COLORADO
Department of Transportation

June 4, 2020

RE: Trails at Aspen Ridge Filing #2 (Springs East at Waterview) - EA-SF1927

TRAILS AT ASPEN RIDGE			
FILING NO. 1 ROADWAY & STORM IMPROVEMENT PLANS			
BRADLEY ROAD SIGNING & STRIPING			
DESIGNED BY: NMS	SCALE: TJC	DATE ISSUED: AUGUST, 2019	DRAWING No. SN01-B
CHECKED BY: NMS	HORIZ 1" = 50'	SHEET 17 OF 71	
	VERT. N.A.

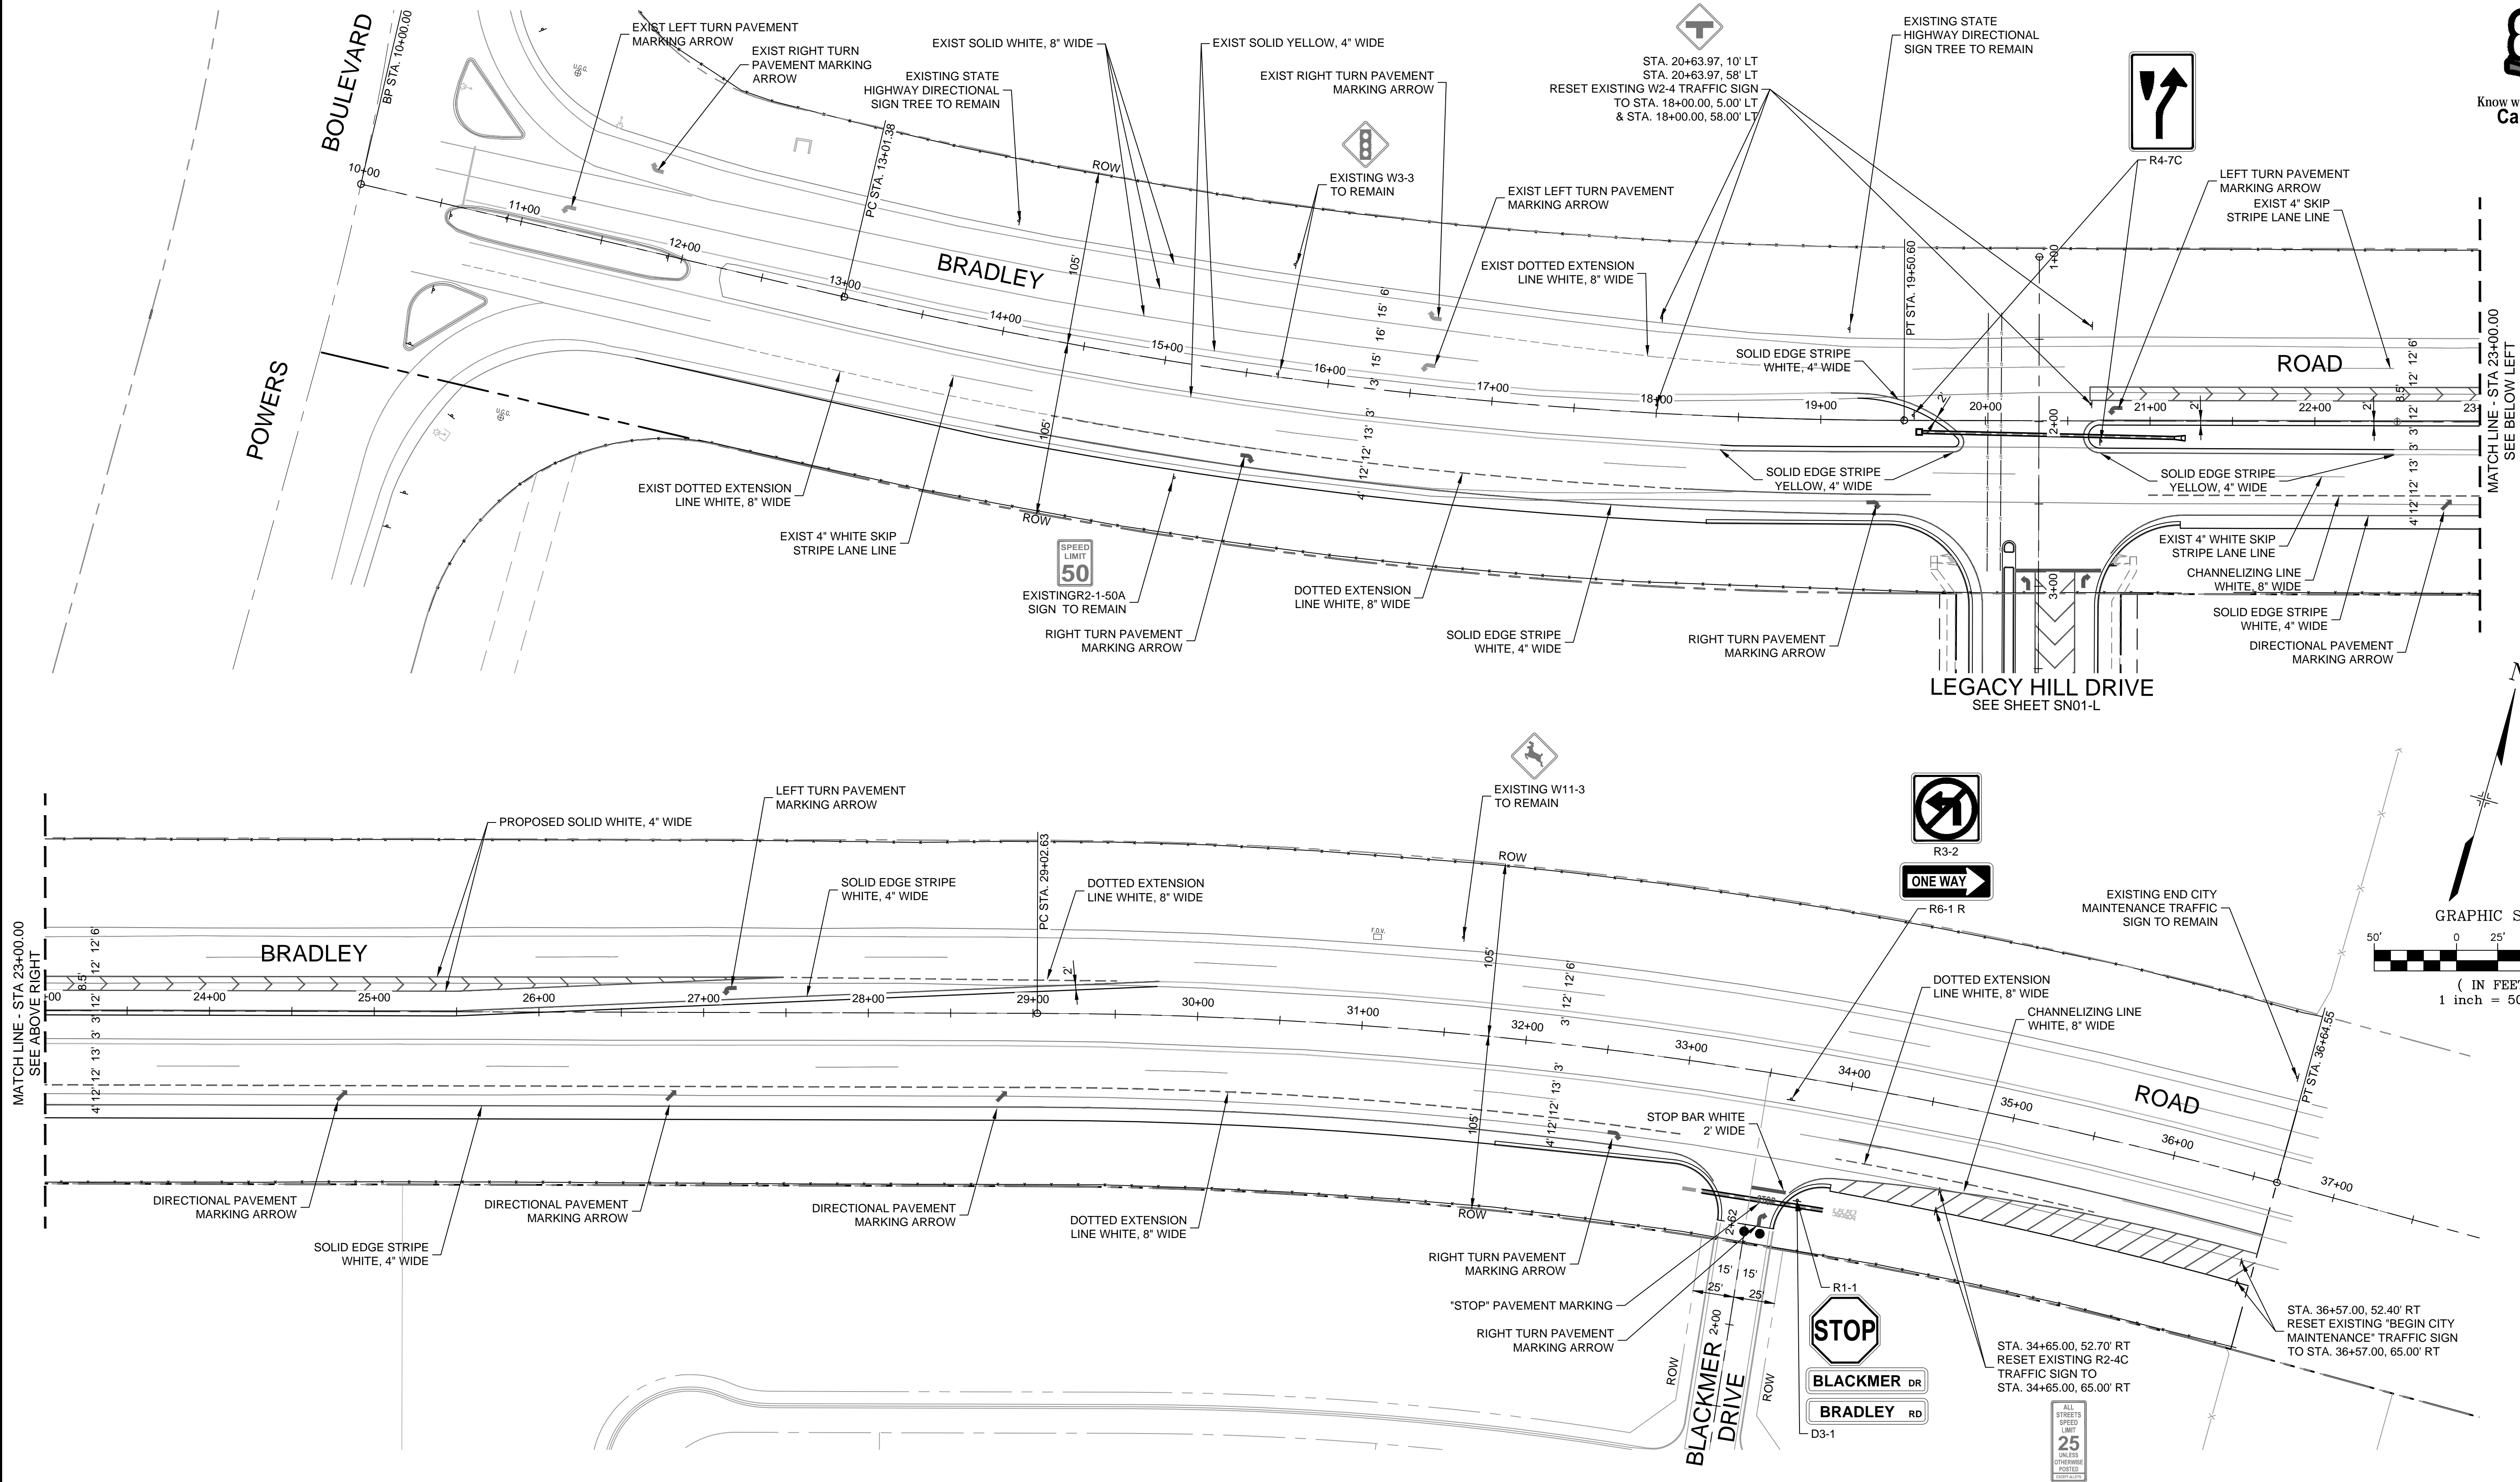
- d. The existing mast arm will need to be lengthened for the second left turn.
- e. Bradley Road has been restriped for dual westbound to southbound left turn lanes when the signal was installed; This will be required as part of the Access Permit, please update table 4.
